From: Simon Davis
Sent: 31 May 2019 15:53
To: Planning.Responses
Subject: FW: BN/35/19/DOC Lake Lane
Attachments: Dwg 1748-52A External Lighting-Lake Lane- Barnham.pdf; DWW Pharola_DS_2pp_02.02.pdf

From: Nicholas Lack [REDACTED]
Sent: 31 May 2019 13:38
To: Simon Davis [REDACTED]
Cc: David West <[REDACTED]> Chris Monk <[REDACTED]>
Subject: BN/35/19/DOC Lake Lane

I have consulted with my client and in response to the Environmental Health officer's consultation we wish to amend the external lighting proposal by selecting a 'dark skies' compliant light fitting.

Pharola DS

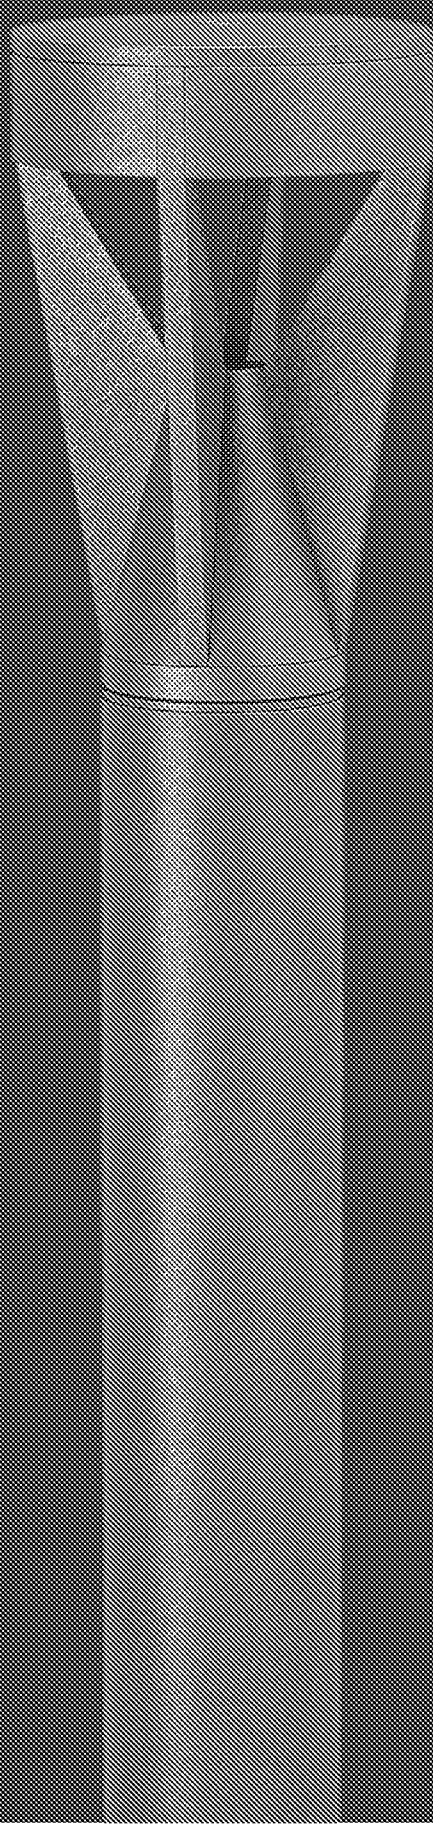
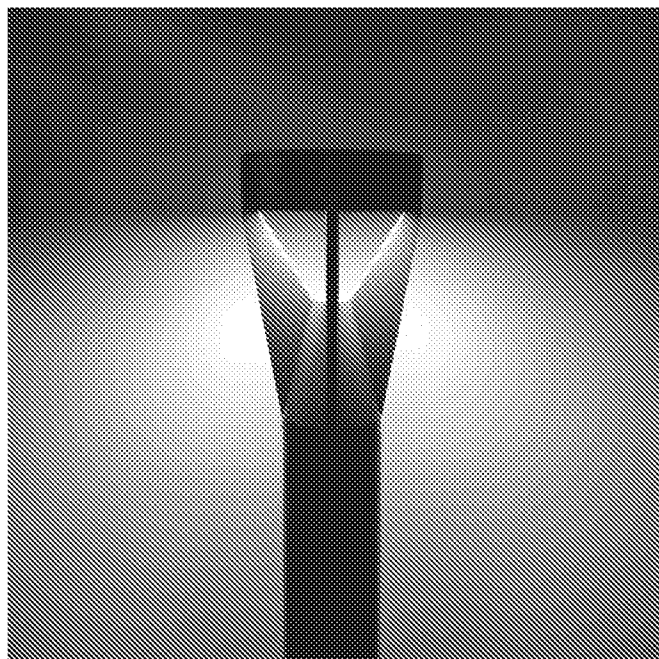
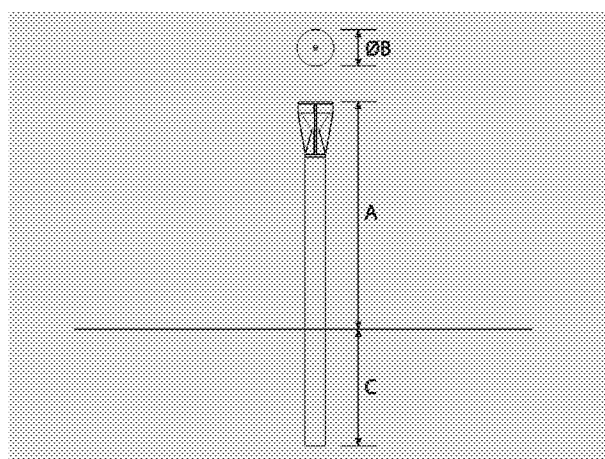
Please see attached response from Environmental Health. Can you provide on illumination levels and light spillage from the proposed lighting and justification as to why downward facing light sources are not being used.

The 'Pharola' bollard selected does not emit 'upward' light but does illuminate sideways, in keeping with its purpose to illuminate specific areas of the private access road there by allowing safer passage for the residents during darkness.
